CITY OF ALBUQUERQUE

**RE: Cutler Right-of-Way Dedication
Grading and Drainage Plan
Engineer's Stamp Date: 10/15/21
Hydrology File: H17D036**

Based upon the information provided in your submittal received 10/25/2021, the Grading and Drainage Plan is **not** approved for Work Order and for action by the DRB on Preliminary Plat. The following comments need to be addressed for approval of the above referenced project:

MASTER DRAINAGE PLAN CUTLER R/W  
1" = 20'

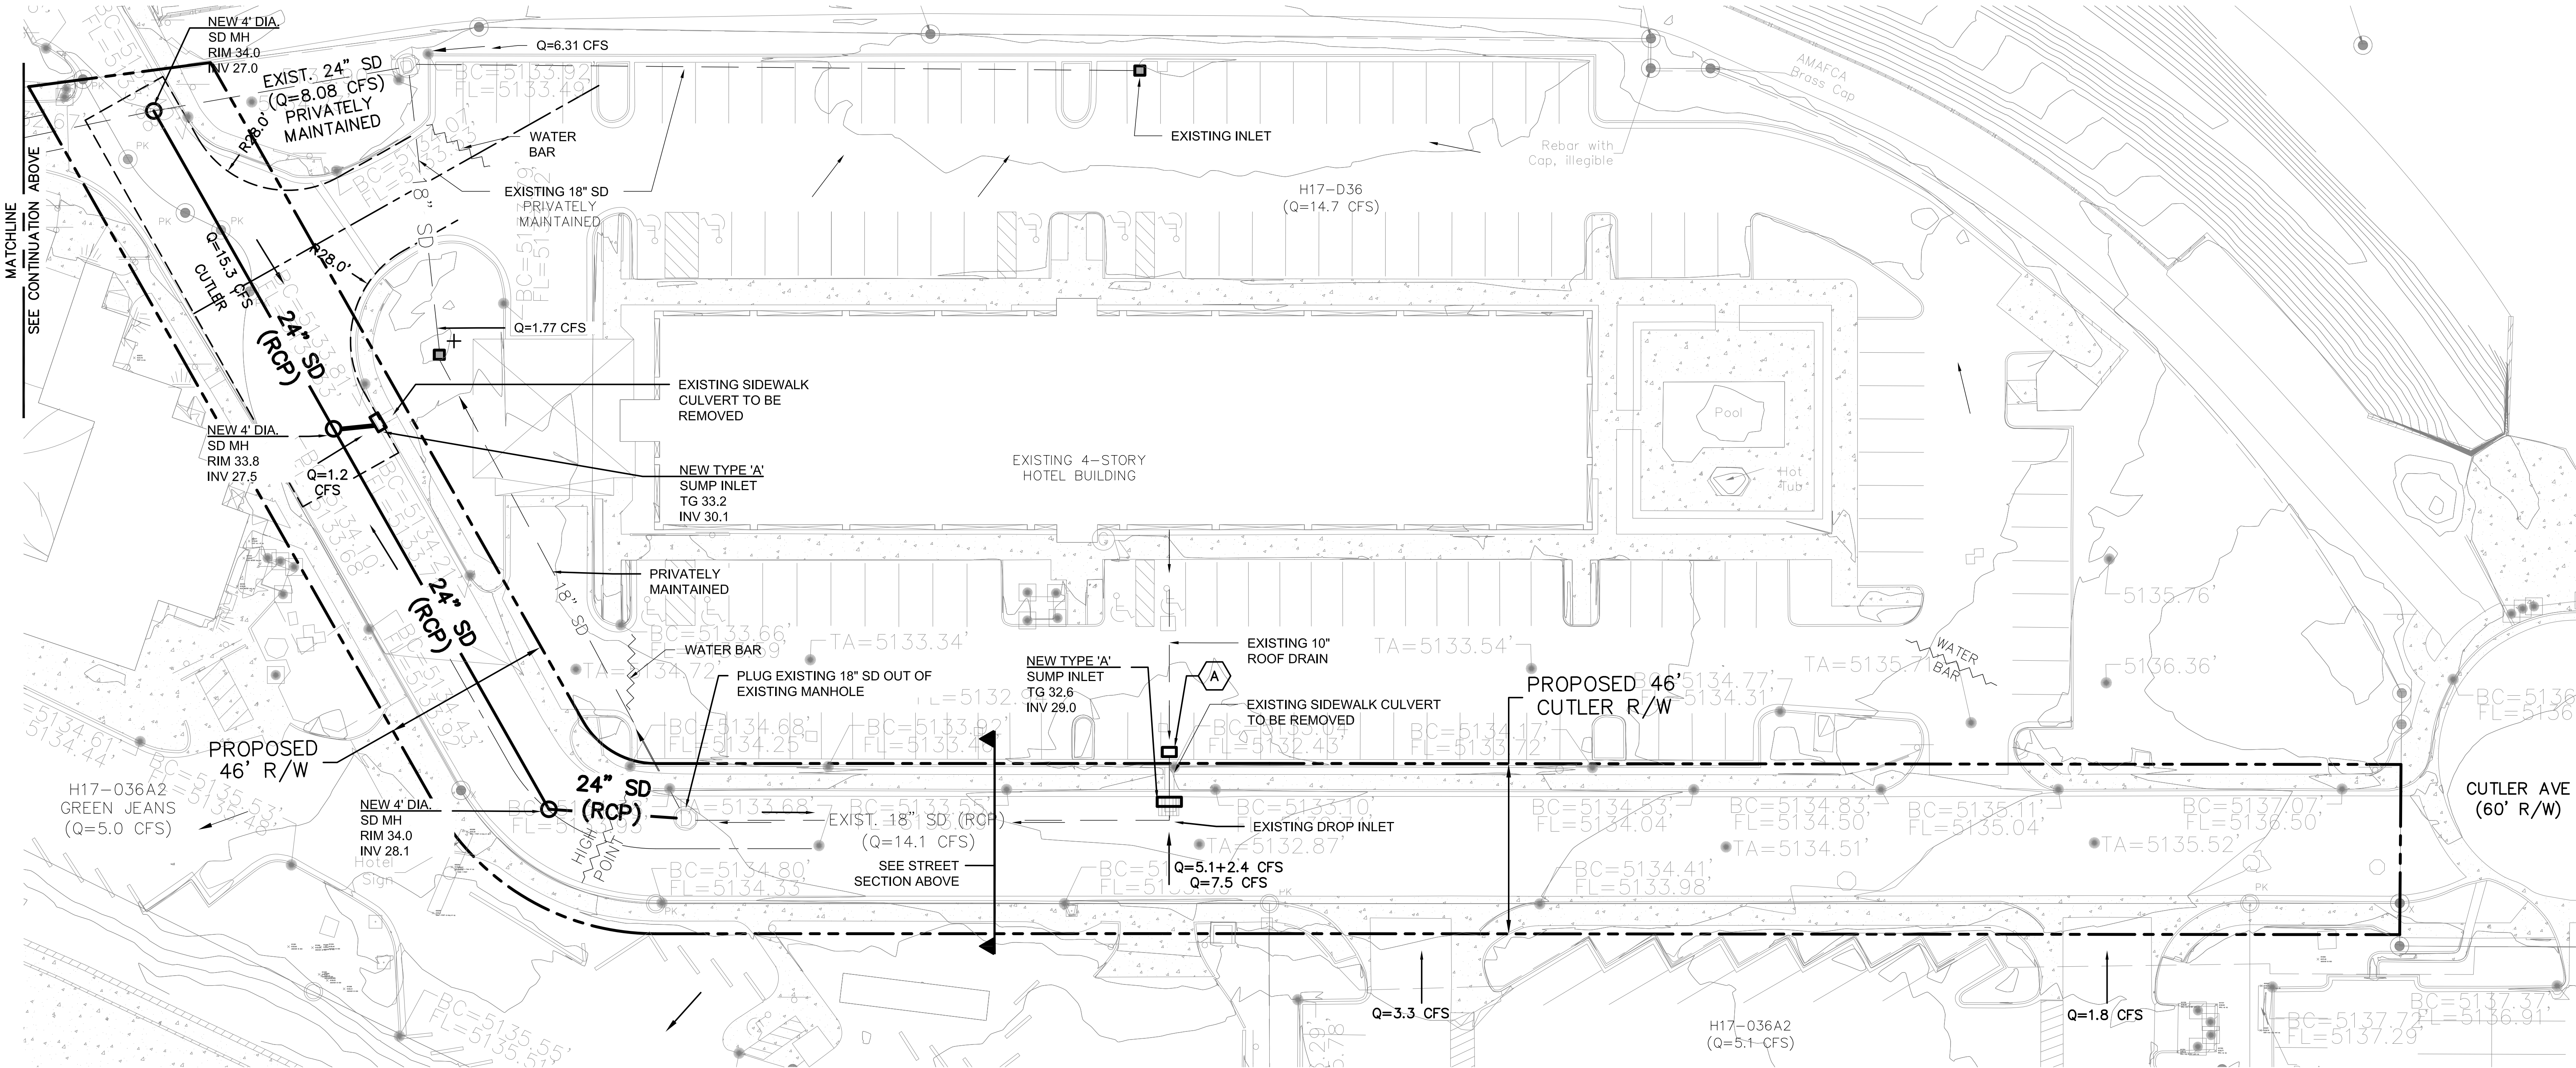
1. Please provide the proposed Cutler Rd R.O.W. Also, please show the proposed turn-around at the end. This line work is very light and merges with all the existing line work.

2. **Repeat comment** - Please verify the pipe size, material of the existing storm sewer. Also, please provide the rim elevation of the manholes, pipe inverts, inlet top of curb elevations.
3. **Repeat comment** - Also, please include any changes that will be done for the Work Order on the Grading Plan. For example, at the cul-de-sac the road will be flattened and straightened. (please see image below)

4. The drainage calculations needed for this should only be for the proposed Cutler Rd R.O.W. (this is the acres). All adjacent commercial tracts are considered off-site flows. This entire watershed should be shown with the off-site drainage areas shown as well. This should be the drainage map for the calculations.
5. Please provide the proposed cross-section of the proposed Cutler Rd. R.O.W.
6. Please provide the street calculations for the above proposed Cutler Rd. R.O.W.
7. Please provide the storm pipe calculations.
8. In order to install the new Type A inlet in Cutler Rd, the existing sidewalk culverts will have to be removed, a new proposed private inlet and a new proposed HDPE pipe to the back of the new Type A inlet.

9. Same as above, in order to install the new Type A inlet in Cutler Rd, the existing sidewalk culverts will have to be removed.

10. Please label all private storm pipes as "Privately maintained".

11. Please show and label the proposed 10' Public Drainage Easement.
